Immingham Green Energy Terminal

9.12 Draft Statement of Common Ground between
Associated British Ports, Air Products (BR) Limited and
North East Lincolnshire Council

Planning Inspectorate Scheme Ref: TR030008

Document Reference: TR030008/APP/9.12

**FIGURE NUMBER**  
Figure 13.3

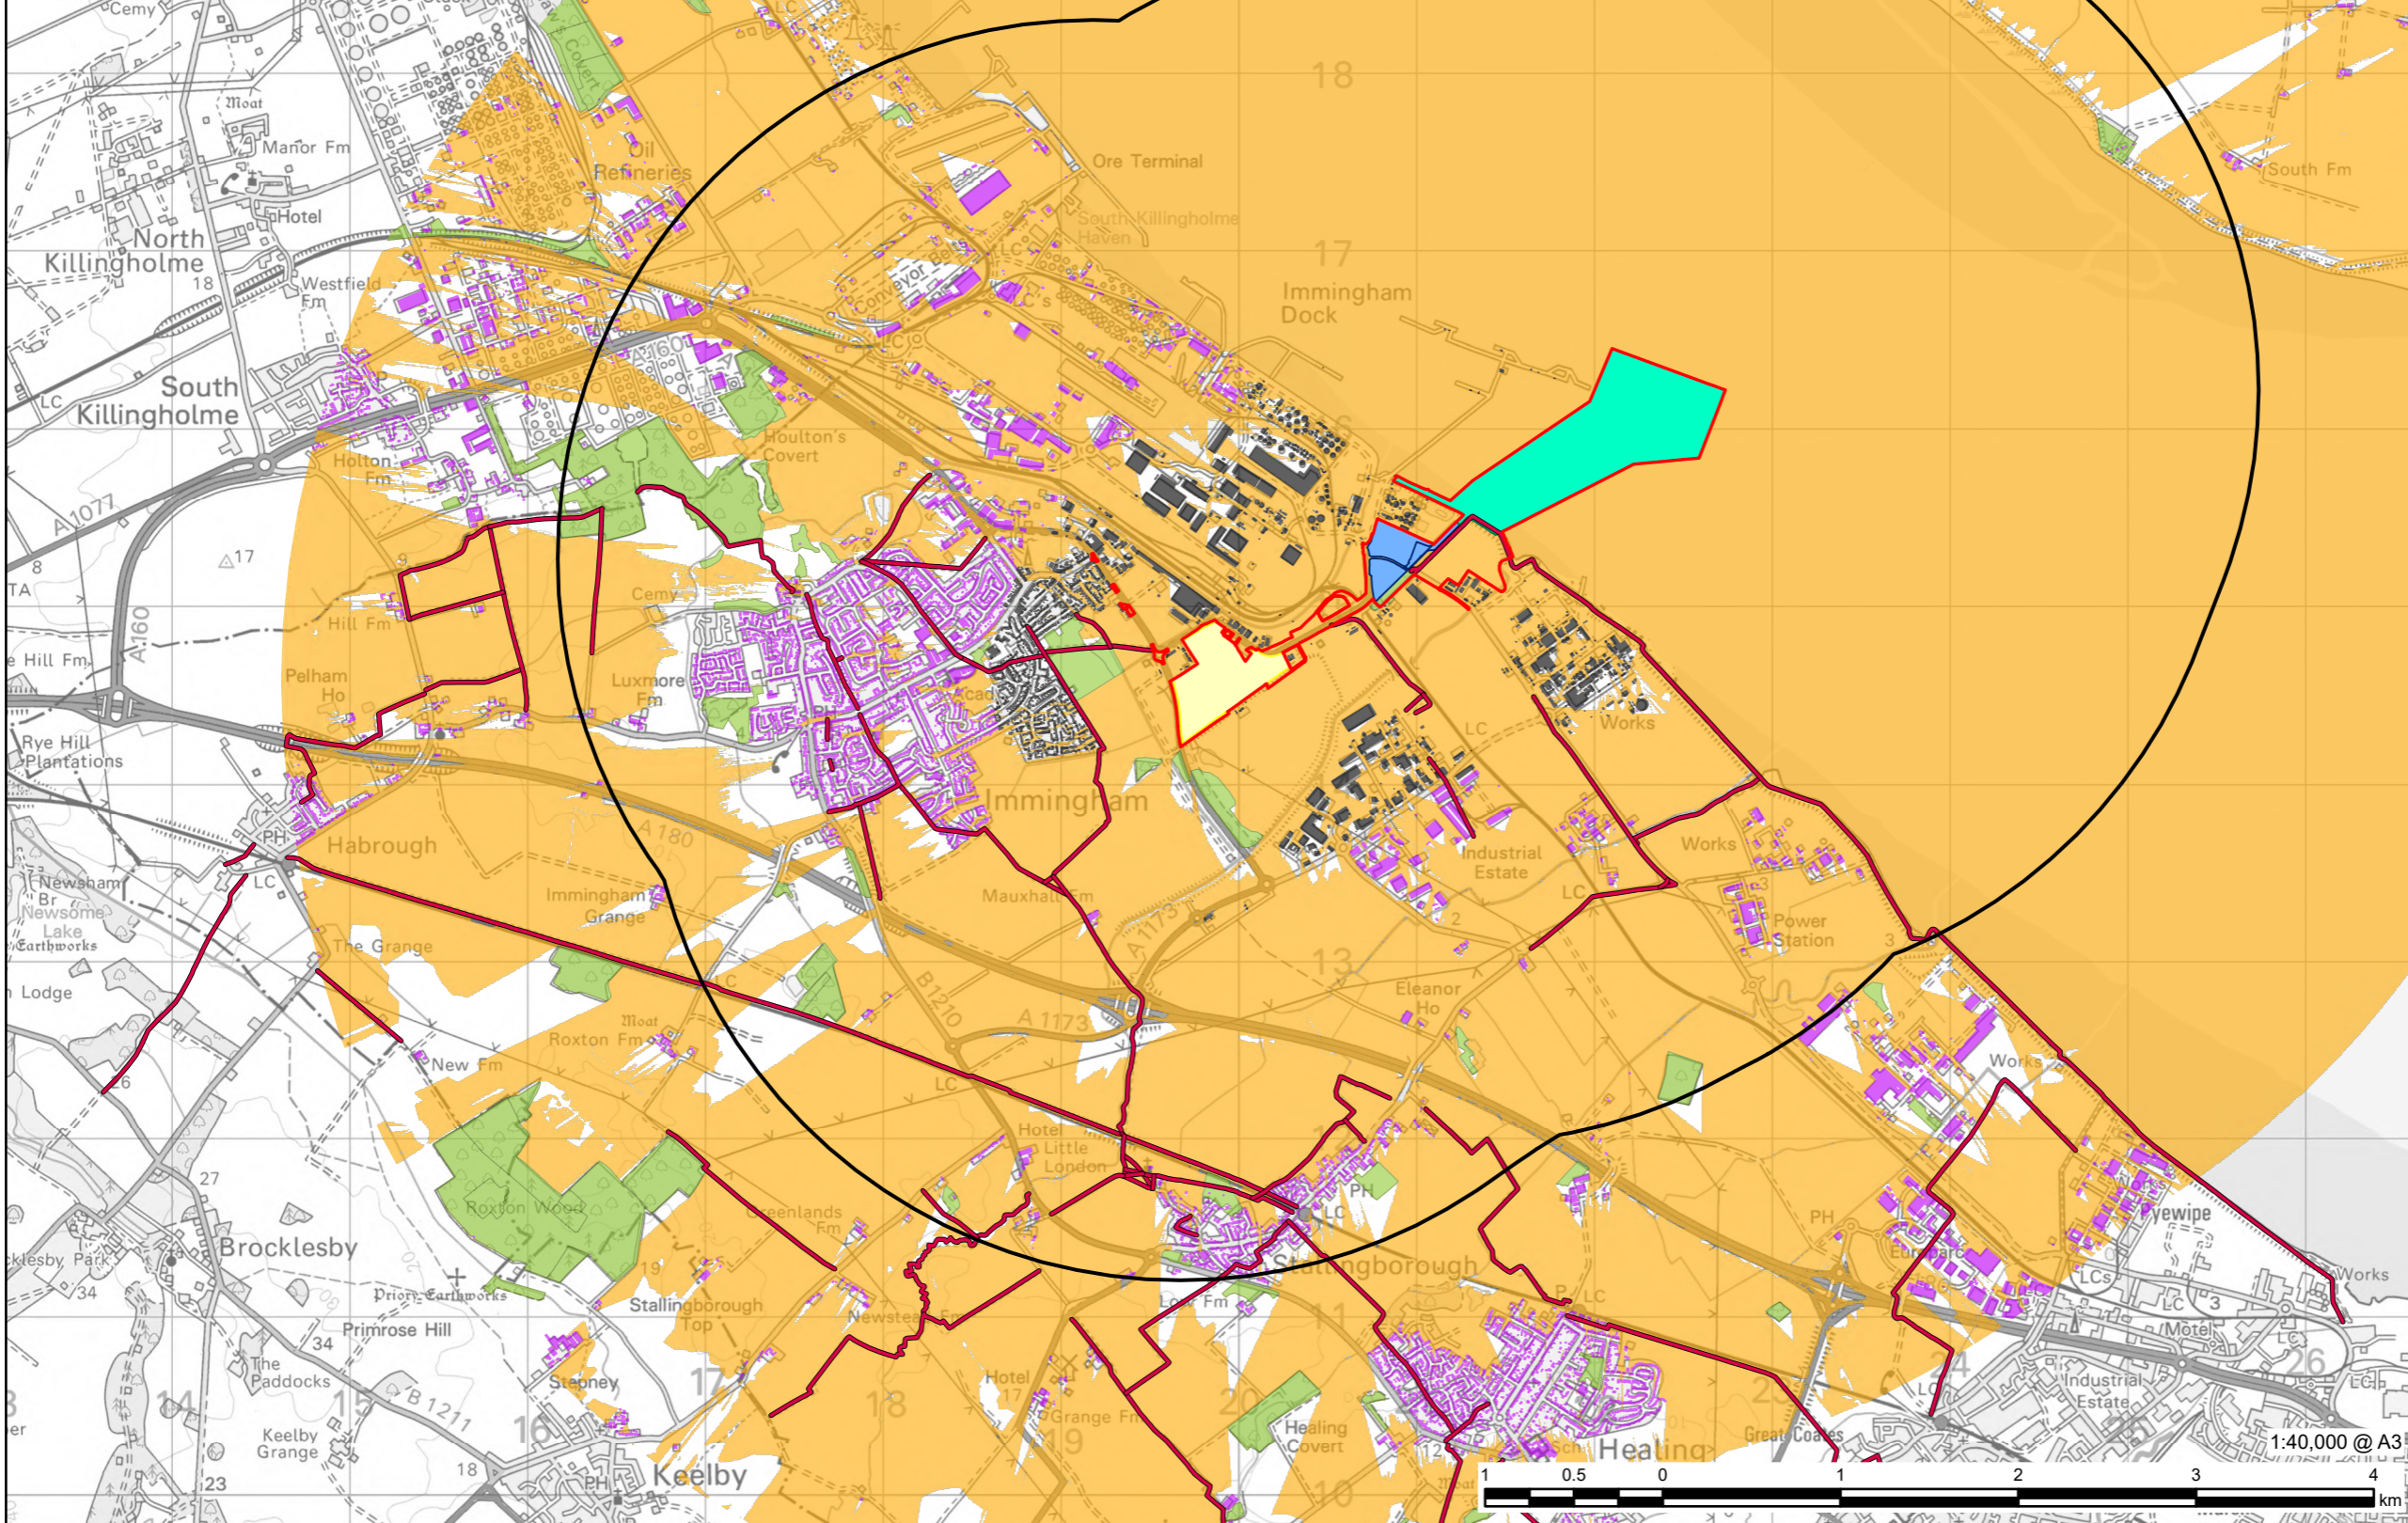
ID	Matter	Reference	NELC Position	ABP Position	Air Products Position	Status	Date
LV2	Mitigation measures – visual screening	<p>6.2 Environmental Statement – Chapter 13: Landscape and Visual Impact [APP-055]</p> <p>6-3 Environmental Statement Figures - Figure 13.8.1 to 13.8.13 [APP-115].</p> <p>6-3 Environmental Statement Figures - Figure 13.9.1 to 13.9.13 [APP-116].</p>	<p>Consideration should be given to how the development can be screened, at least for the near views, and for those residential properties on the edge of Immingham closest to the development.</p>	<p>Views from residential properties to the south east of Immingham have been considered in the ES Chapter 13: Landscape and Visual Impact [APP-055] within Viewpoint 6 (PRoW to the rear of Ings Lane/Talbot Road). Baseline views are represented in Figure 13.8.8 Summer Viewpoint Photography [APP-115] and Figure 13.9.8 Winter Viewpoint Photography [APP-116]. An indicative representation of the Project is illustrated in Figure 13.10.6 Photomontage [APP-117].</p> <p>The assessment at Viewpoint 6 states that “<i>taller structures associated with East and West Site would be partially visible on the skyline, however, intervening vegetation would assist in screening.</i>”</p> <p>It is acknowledged that there is likely to be some views of the taller structures from residential receptors where there is limited screening from existing boundary vegetation, as described within the baseline view.</p> <p>Native woodland planting is proposed along the western</p>	As per ABP response.	Discussion ongoing

ID	Matter	Reference	NELC Position	ABP Position	Air Products Position	Status	Date
		6-3 Environmental Statement Figures - Figure 13.10.1 to 13.10.6 [APP-117]. 6.9 Outline Landscape and Ecology Management Plan [APP-225] Relevant Representation [RR-022]		boundary of the West Site and is outlined within the oLEMP [APP-225] and illustrated on Figure 1 Indicative Landscape and Biodiversity Plan of the oLEMP, to provide additional screening of the Project from views located to the south-west of the Site. The landscape and visual assessment concludes that the significance of effect during operation on views from residential properties to the south east of Immingham (assessed within viewpoint 6) would be negligible adverse (not significant).			
LV3	Outline Landscape and Ecology Management Plan (oLEMP)	6.9 Outline Landscape and Ecology Management Plan [APP-225]		ABP considers the oLEMP submitted with the application for development consent provides an appropriate framework for development of the final LEMP in regard to landscape and visual matters. ABP is seeking NELC's agreement with this position.	As per ABP position.	Discussion ongoing
